**WELWYN HATFIELD BOROUGH COUNCIL  
EXECUTIVE DIRECTOR - PLANNING, PUBLIC PROTECTION AND GOVERNANCE**

**DELEGATED APPLICATION**

**Application No:** 6/2022/0758/HOUSE  
**Location:** 49 Mulberry Mead Hatfield AL10 9EH  
**Proposal:** Erection of a single storey side extension to facilitate conversion of garage into a habitable space.  
**Officer:** Ms Kirsty Shirley

**Recommendation:** Refused

Proposed Ground Floor Plan

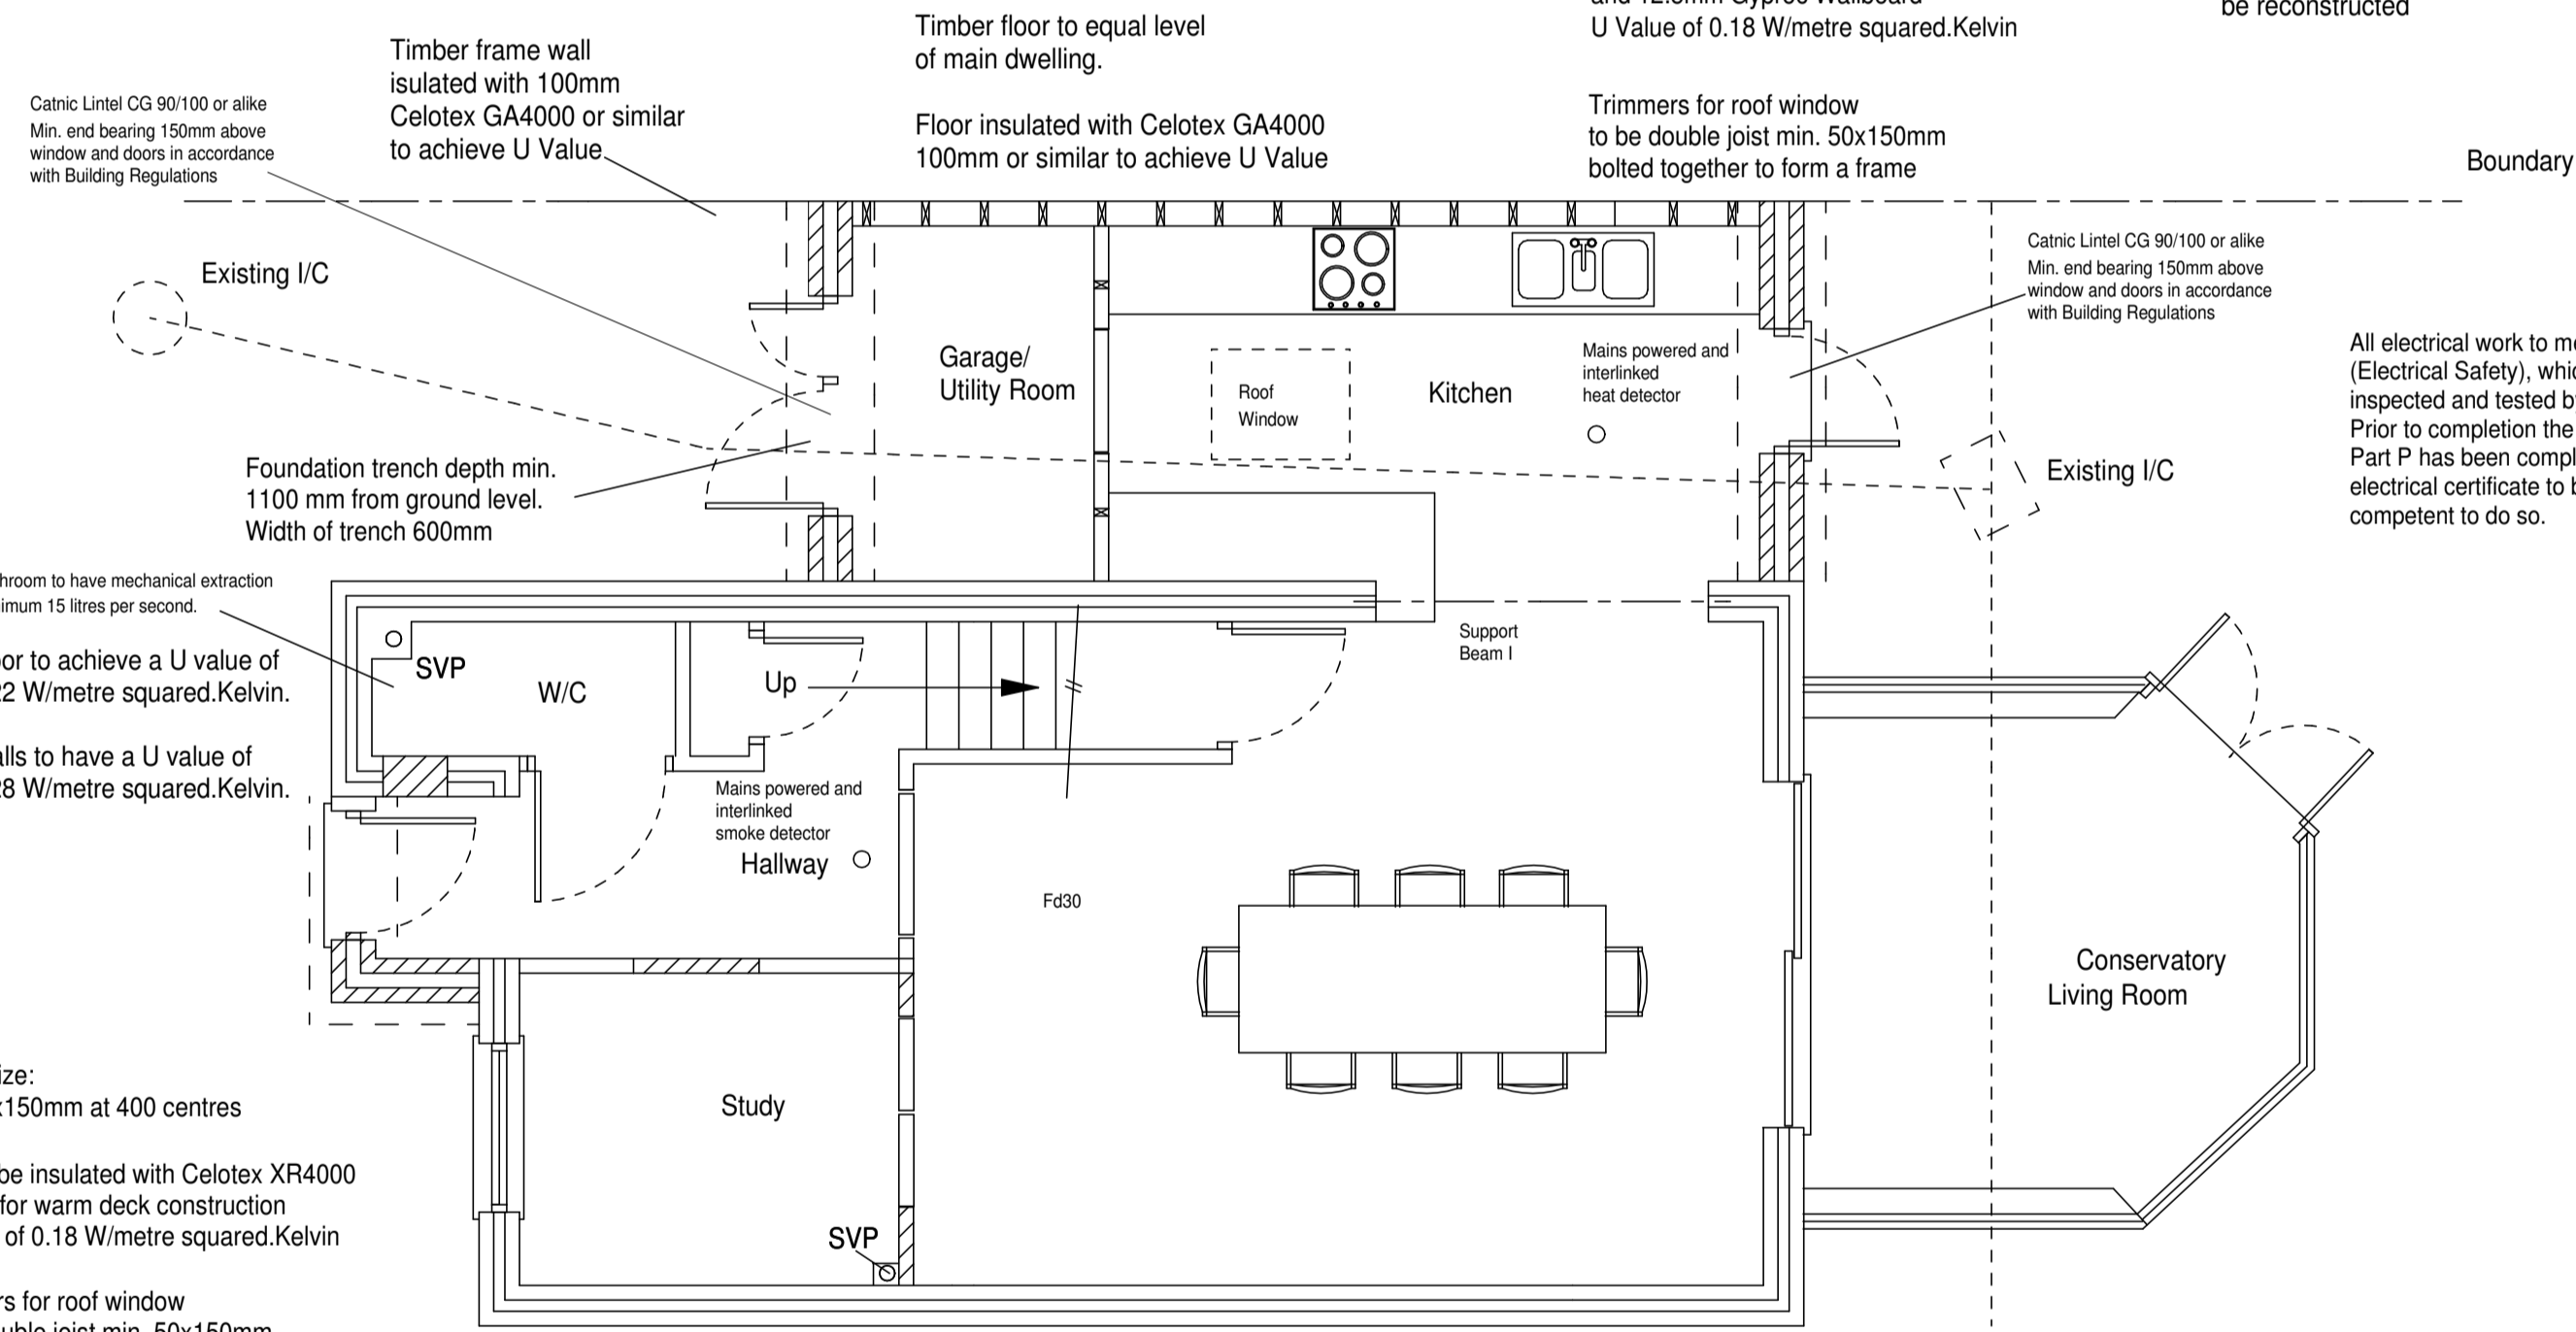
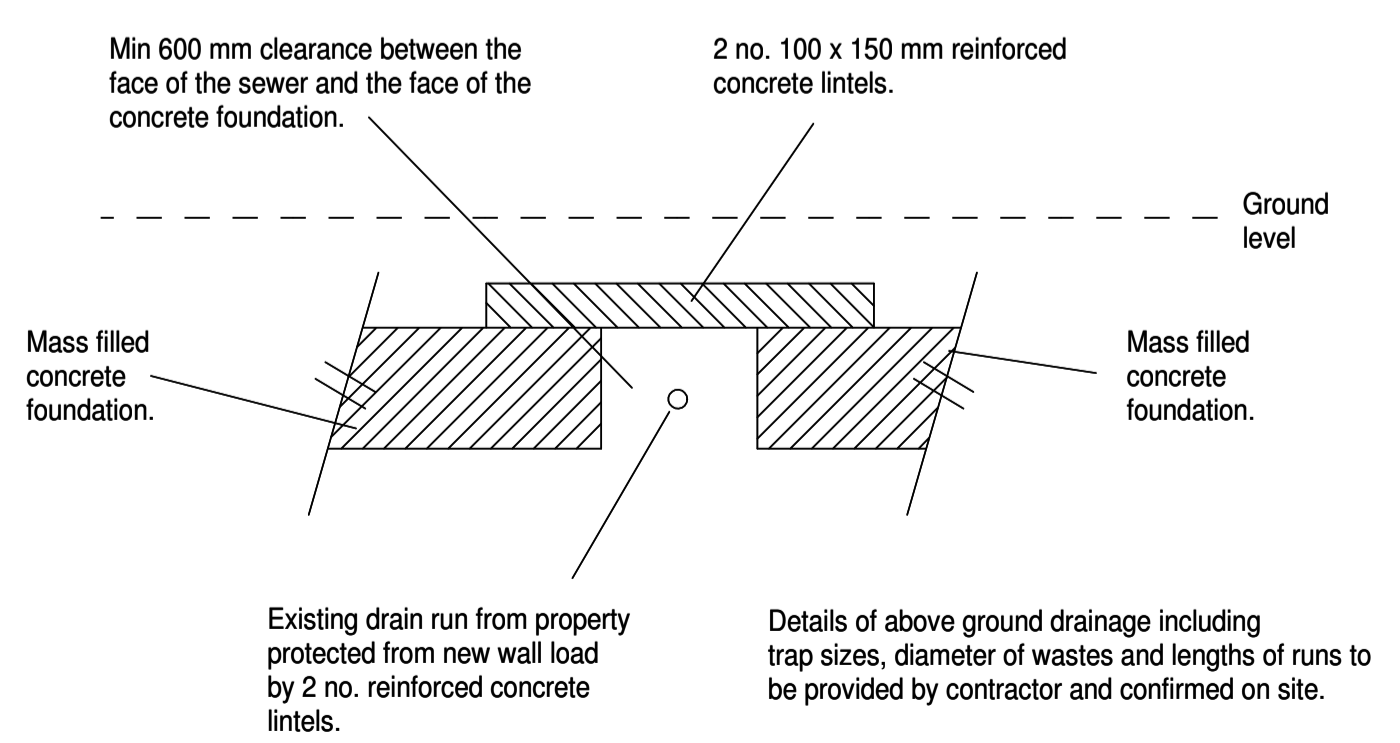
<p>distance from the nearest train station. Nearby facilities and shops are limited.</p> <p>The application site benefits from a front driveway suitable for parking one vehicle. The driveway measures approximately 6.8m in length and approximately 2.5m in width, suitable to park one vehicle.</p> <p>The Interim Policy for Car Parking Standards and Garage Sizes outlines that many existing domestic garages are too small for their intended purpose for parking/storing vehicles. The Council will seek to ensure that new garages have a genuine ability to be used for their intended purpose and will require them to be at least 6 metres long by 3 metres wide and sufficiently tall to accommodate modern cars. Whilst dimensions of the previous garage fall below the identified size requirements, at approximately 5.2m in length and approximately 2.5m in width, these measurements could reasonably park a vehicle. The proposed garage space would be approximately 1.7m in internal length and approximately 2.4m in internal width, with French doors inserted within the front elevation of the resultant garage. The size, scale and access to the resultant garage would not be suitable to park one vehicle.</p> <p>The application site is located in an area that sees driveways, garages, narrowing of roads and a tight highway geometry, and these features limit the ability to conveniently or safely park on the highway, as well as some parking hampering the safe use of footways. Additional parking on the road is likely to add to parking pressures within the vicinity, and this would be harmful to the convenience and safety of other road users and to pedestrians.</p> <p>Moreover, the proliferation of on-street parking would cause harm to the established residential character of the area, by leading to a cluttered appearance of cars parked in an indiscriminate fashion: the original design of the housing estate was carefully considered to minimise visual intrusion of car parking, with the provision of discrete parking courts, set-back driveways and pedestrian only routes. The under provision of two car parking spaces would therefore be unacceptable in this case.</p> <p>If the proposal were to be permitted then it would set an undesirable precedent which would make it difficult for the Council to resist similar development elsewhere. There is considered to be to be a reasonable prospect of similar development being repeated nearby: the wider estate contains many houses that could be extended in the same way, and if that was to be repeated without parking provision that accords with the planning policies and the guidance in the SPG and the Interim Policy referred to earlier, then the cumulative effect would be harmful to highway safety and the character and appearance of the surrounding area.</p> <p>The proposal therefore fails to provide adequate on-site parking to accommodate the proposed development and subsequently fails to overcome previous refusal reason 2 of previous application 6/2021/3353/HOUSE.</p>

The proposal fails to provide adequate on-site parking to accommodate the proposed development. Accordingly, the proposal fails to comply with Policies D1, D2 and M14 of the Welwyn Hatfield District Plan 2005; the Supplementary Design Guidance 2005; the Supplementary Planning Guidance on Parking Standards 2004; and the National Planning Policy Framework.
